A303 Amesbury to Berwick Down Scheme

PINS Reference: TR010025

Wiltshire Council Relevant Representation

Drawing file: TR010025 / TR010025-001748-2.13(1) - Classification of Roads Plan.pdf

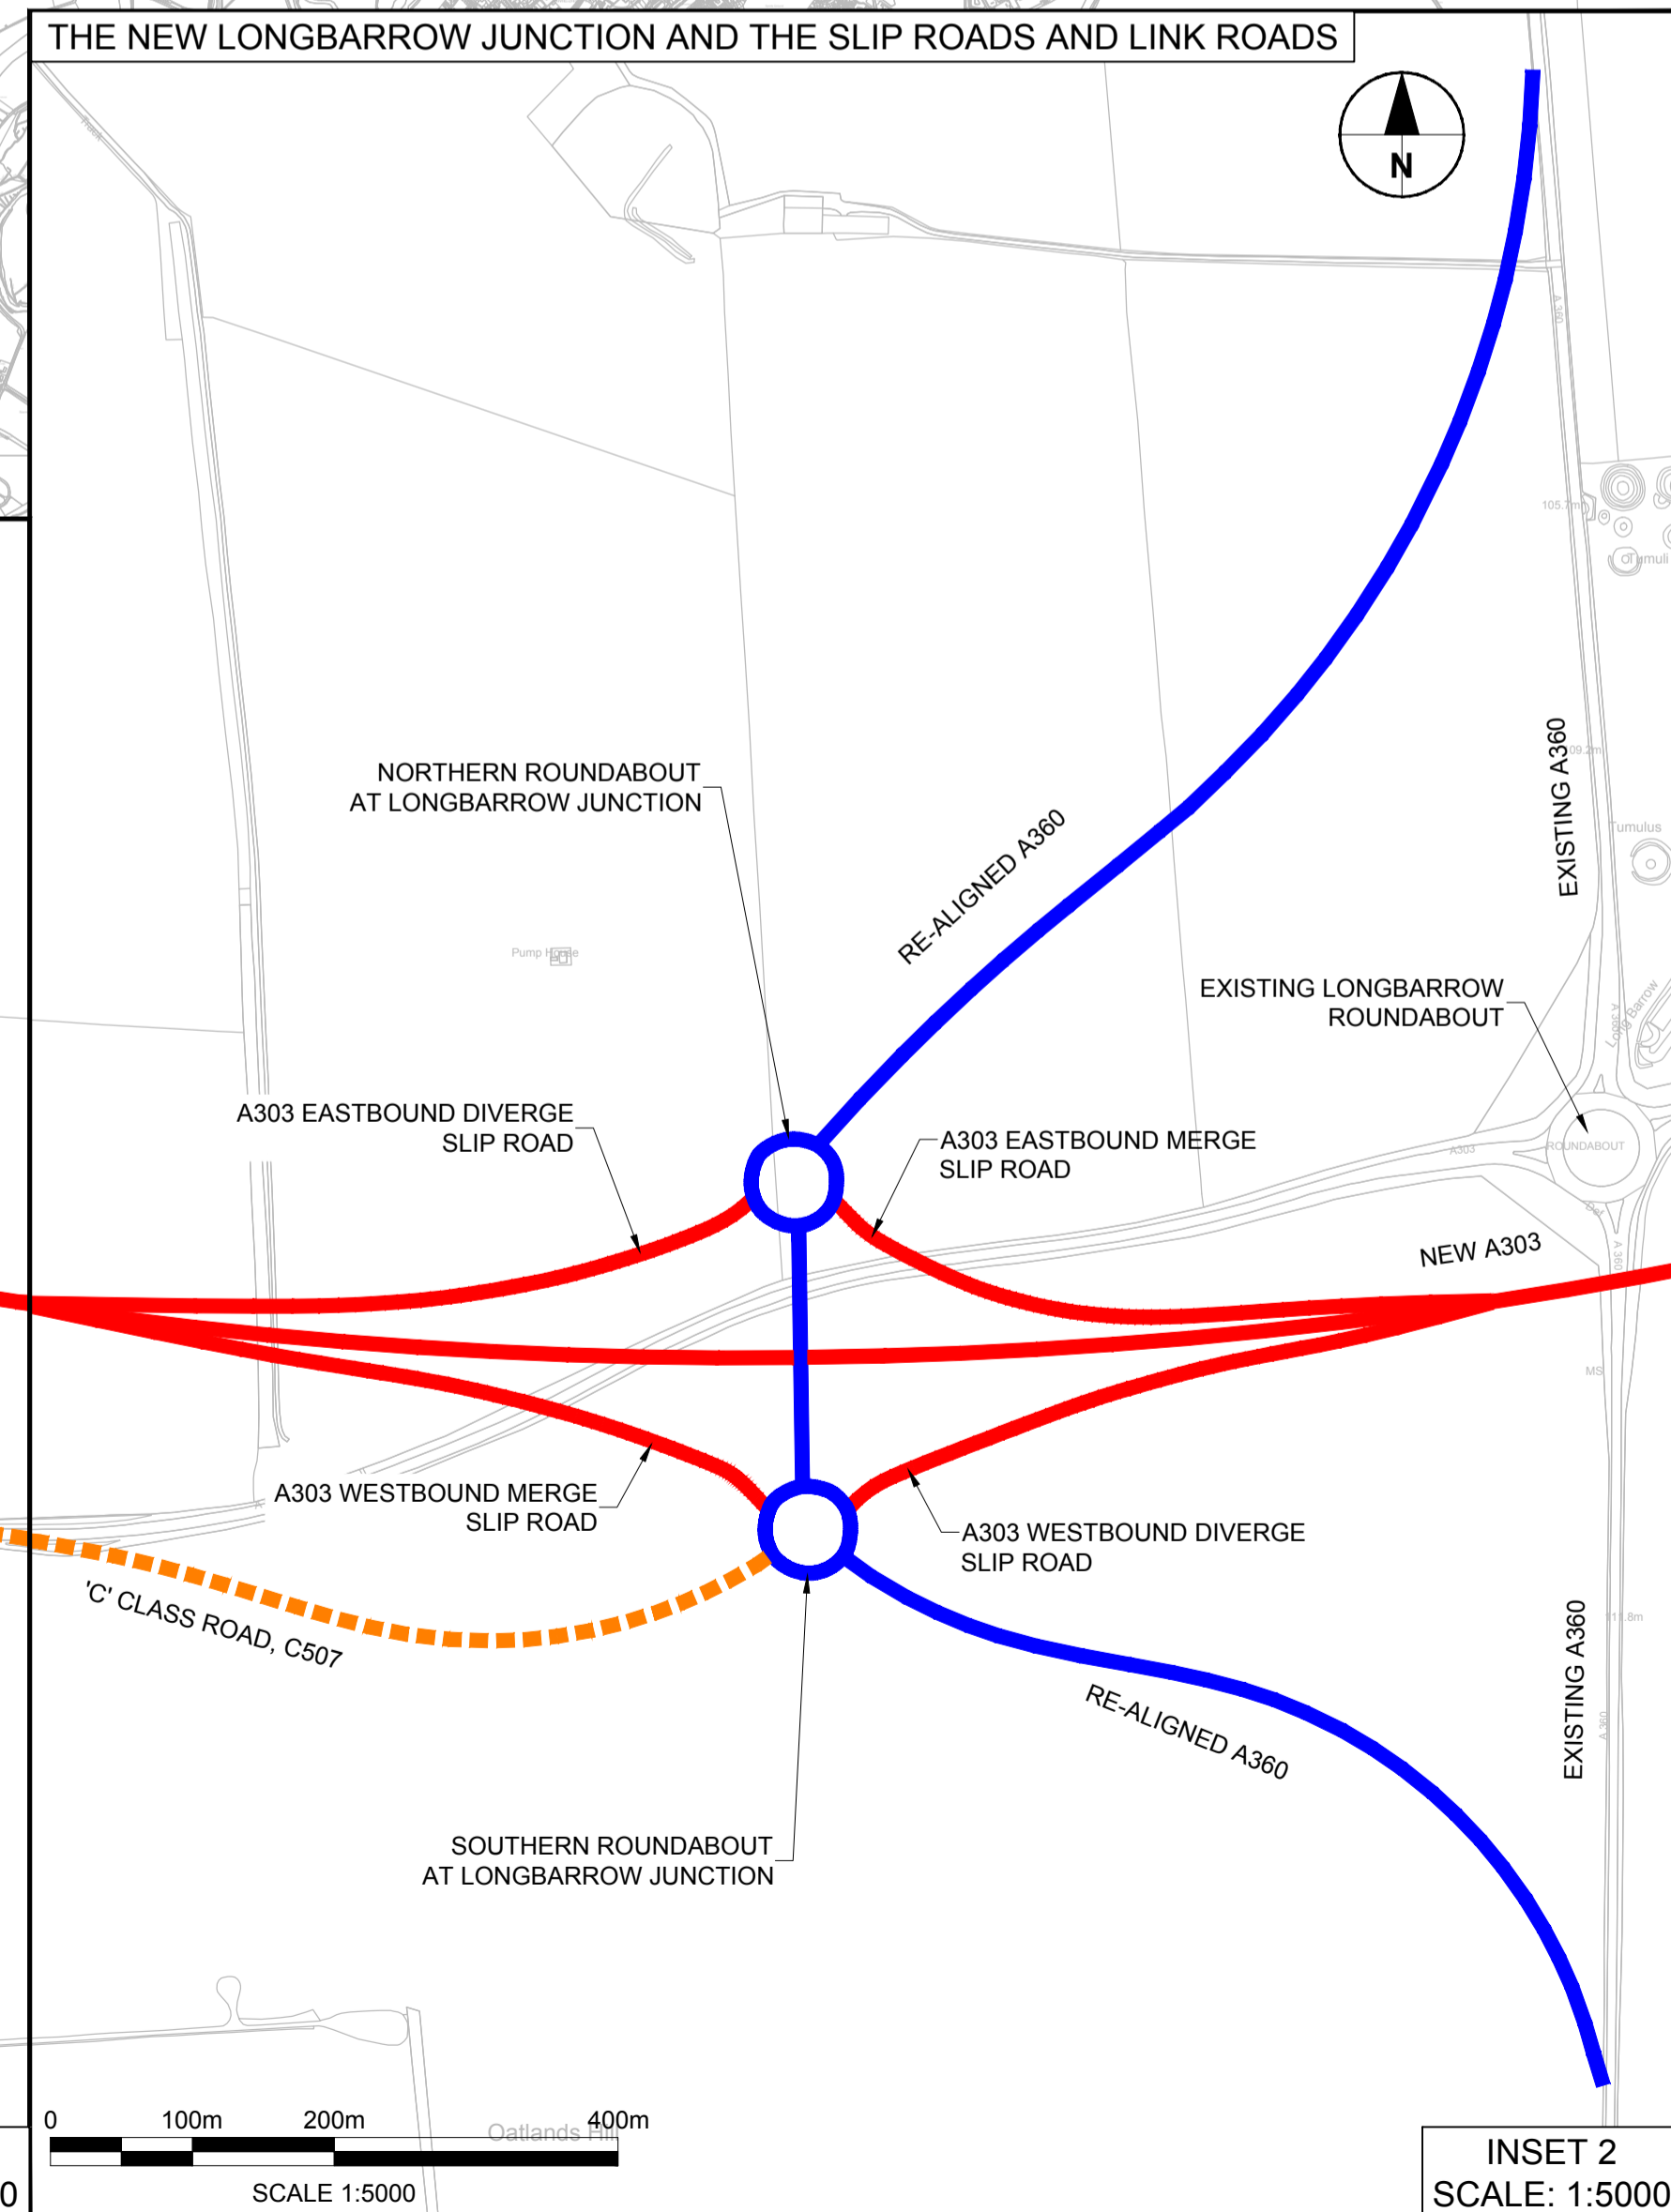
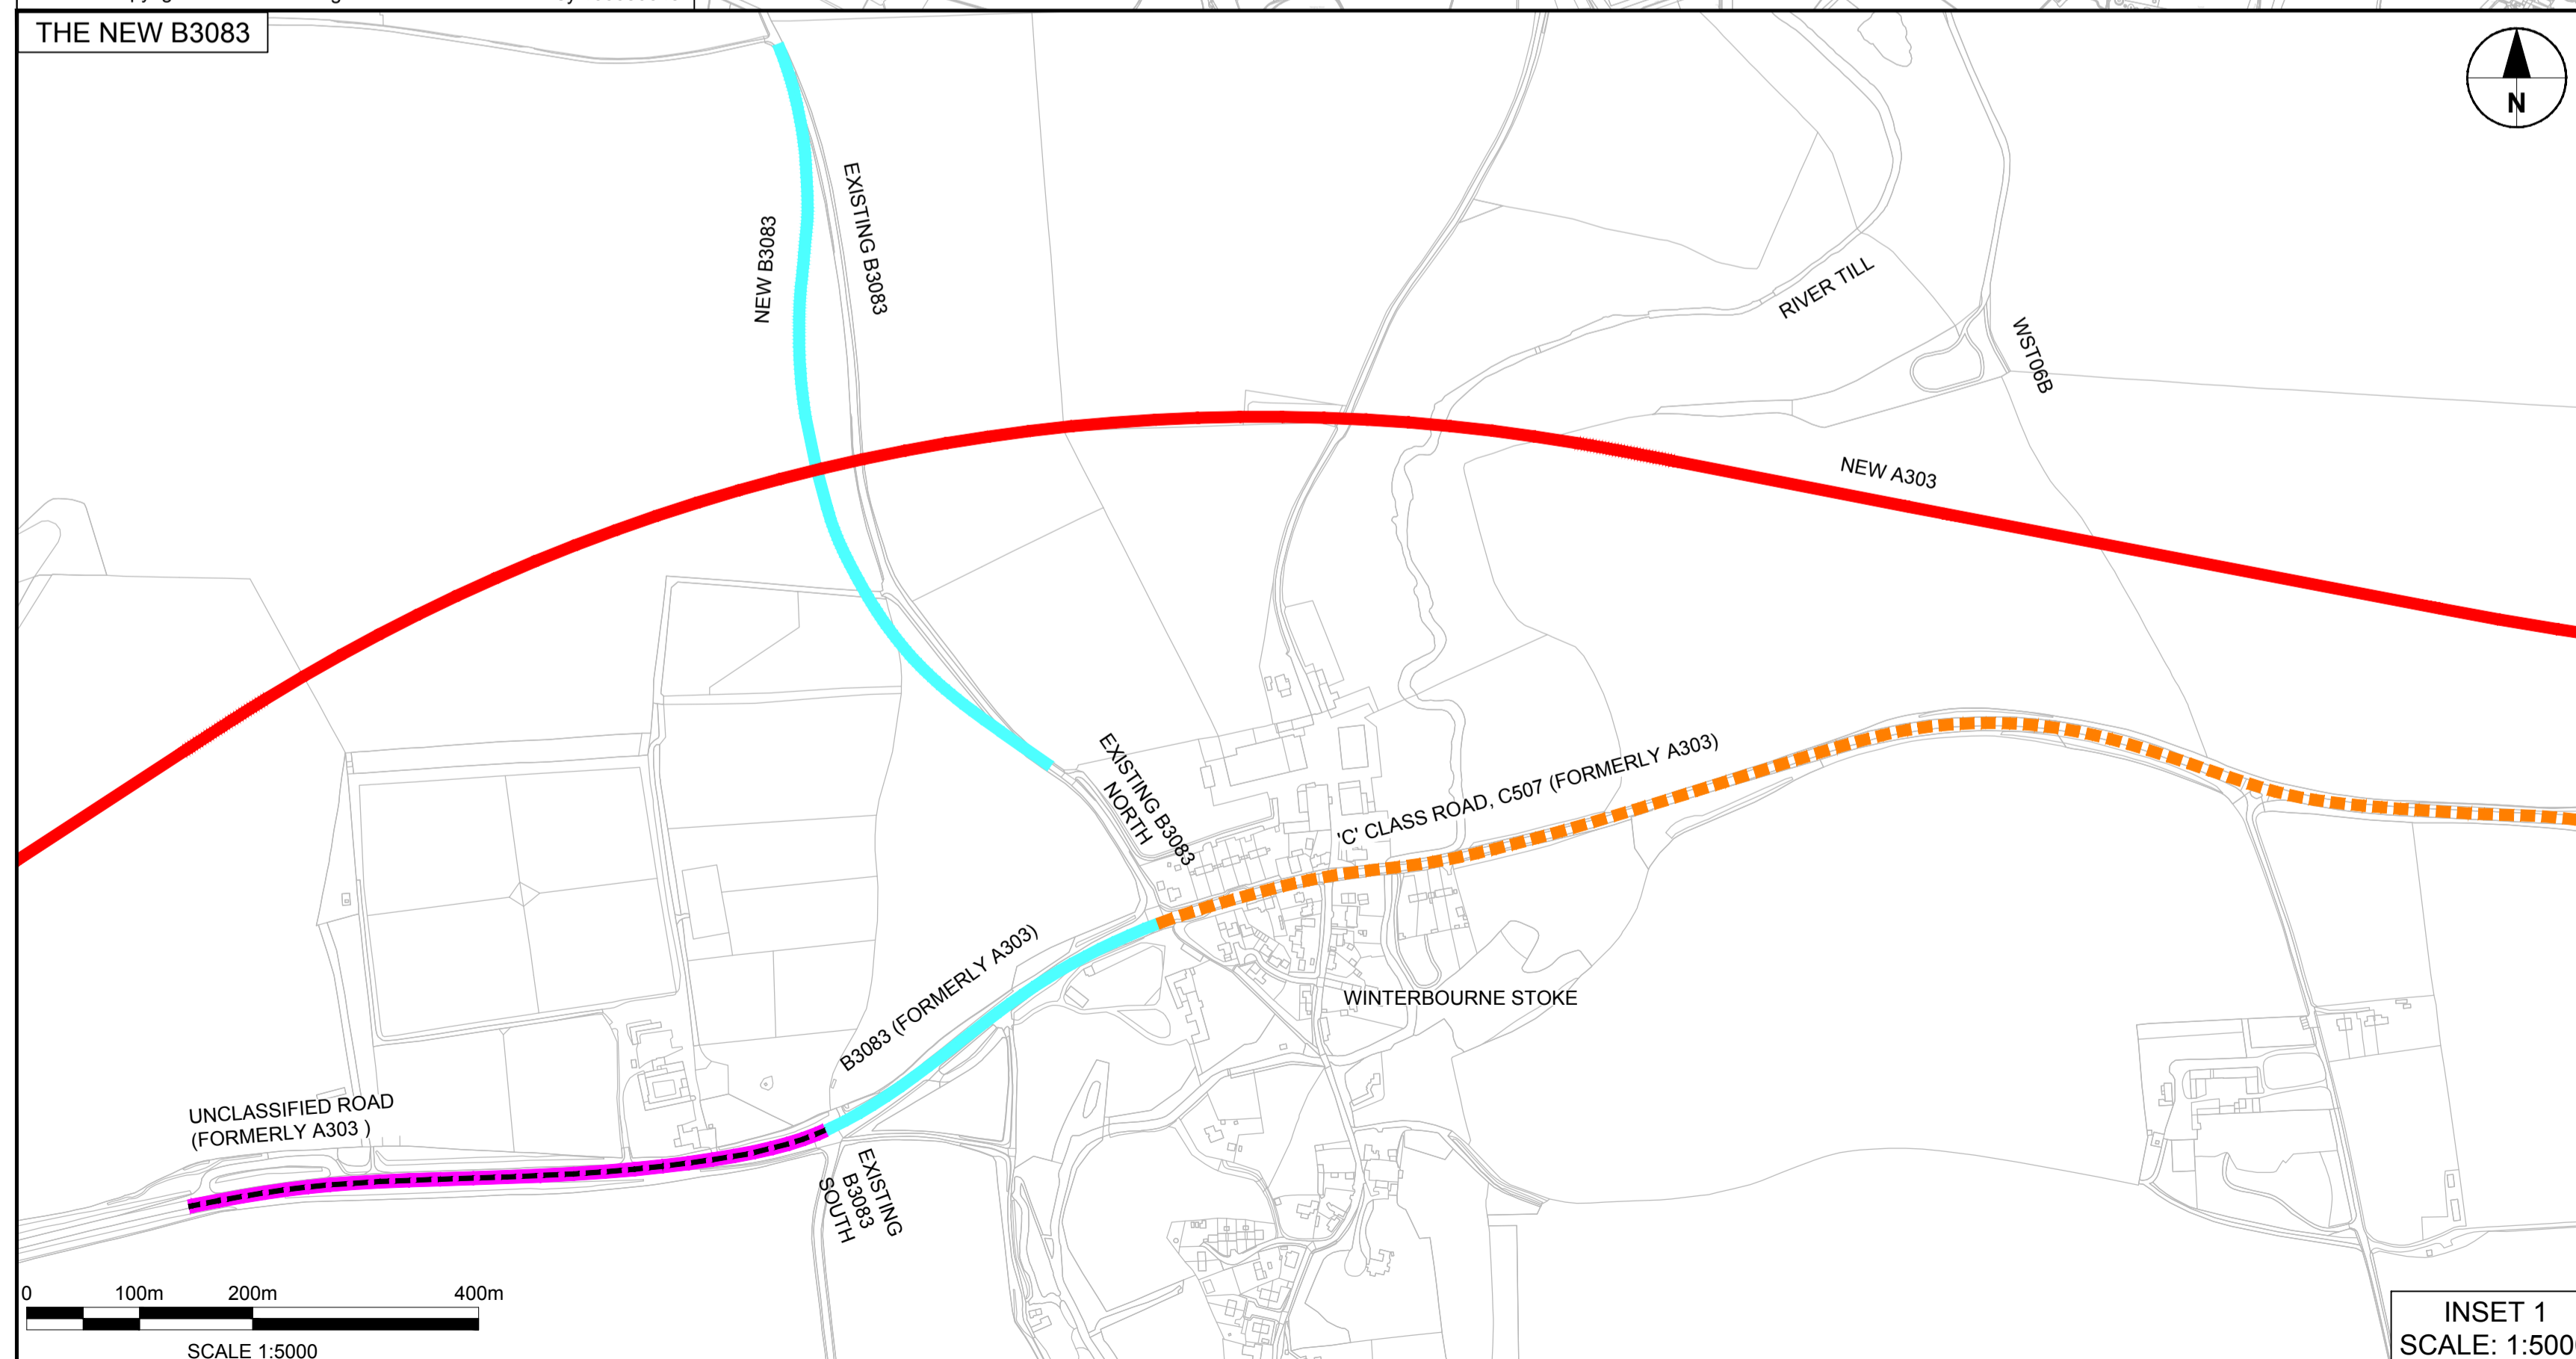
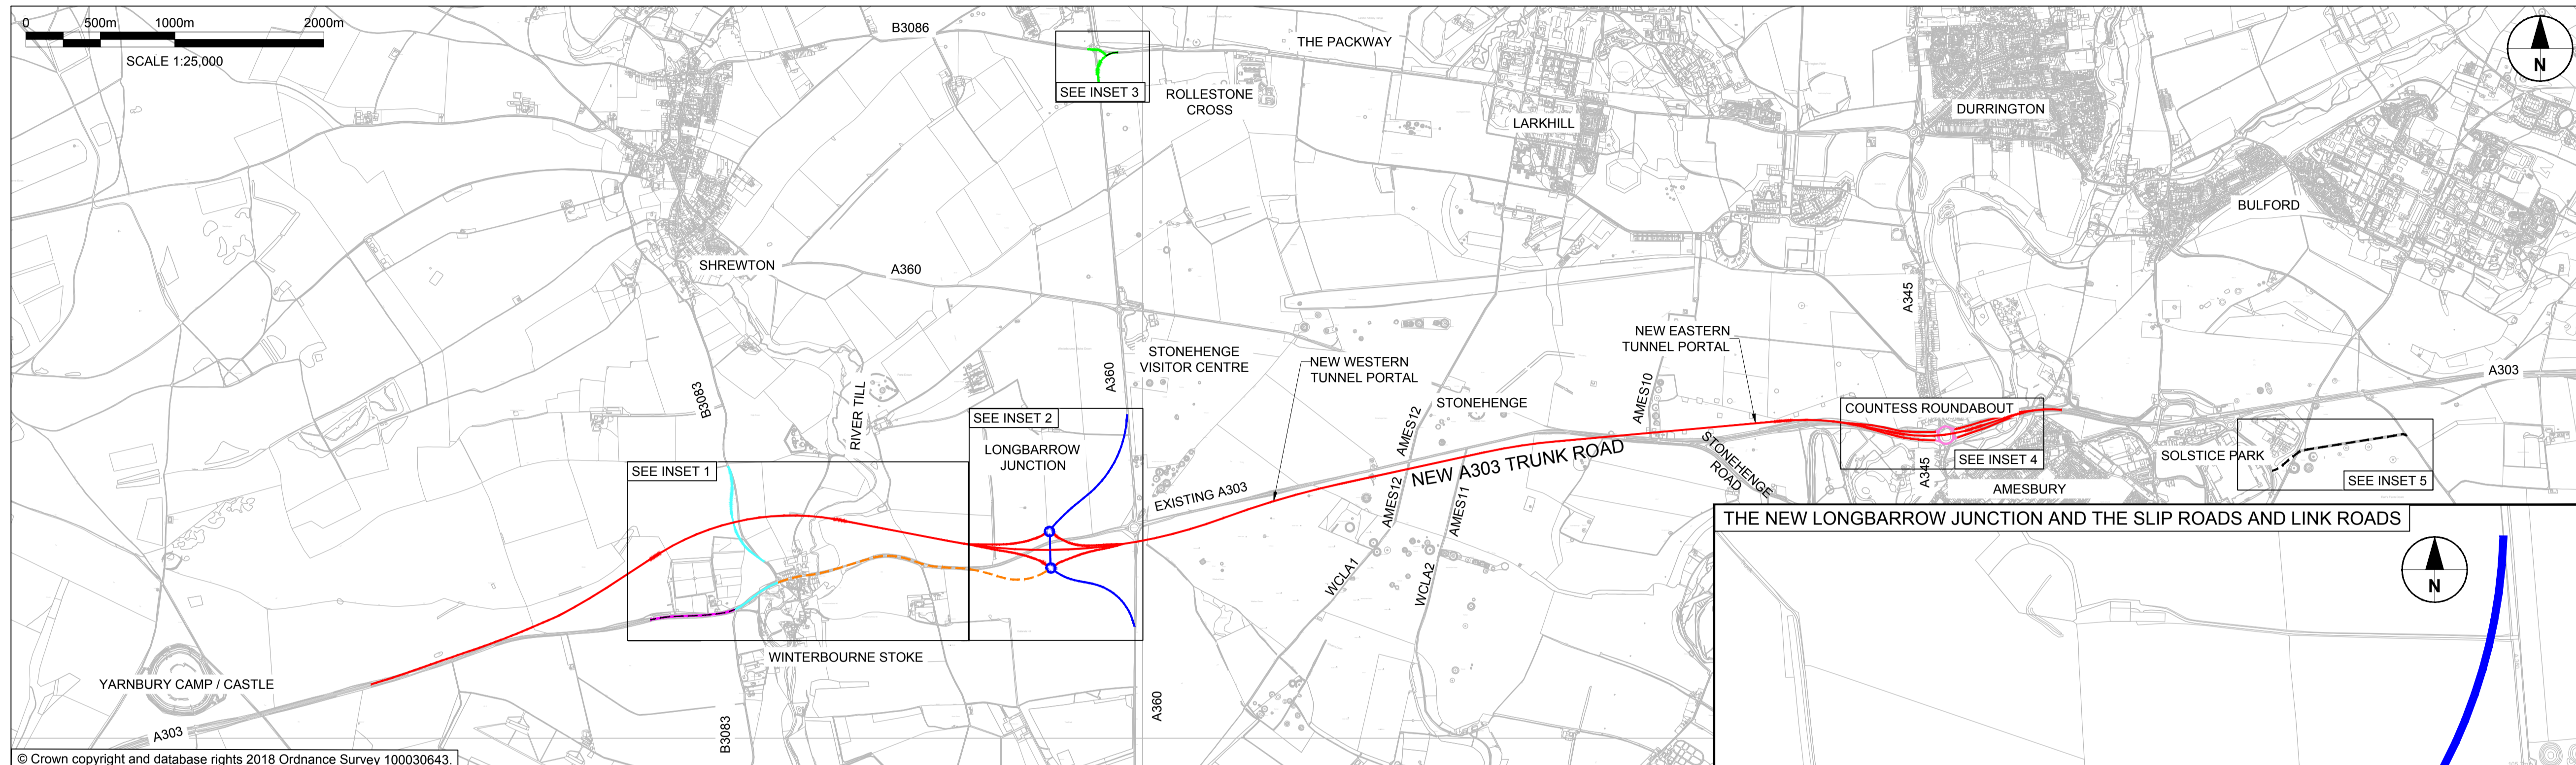
- f) The TR010025 2.13 Classification of Roads Plan does not show any information about the Countess Roundabout. It is currently classified as the A303. As a grade separated trunk road junction, the roundabout should be classified as the A345, consistent with the classification to the principal roads to the north and south. Consideration should be given to this issue in the context of those raised above.
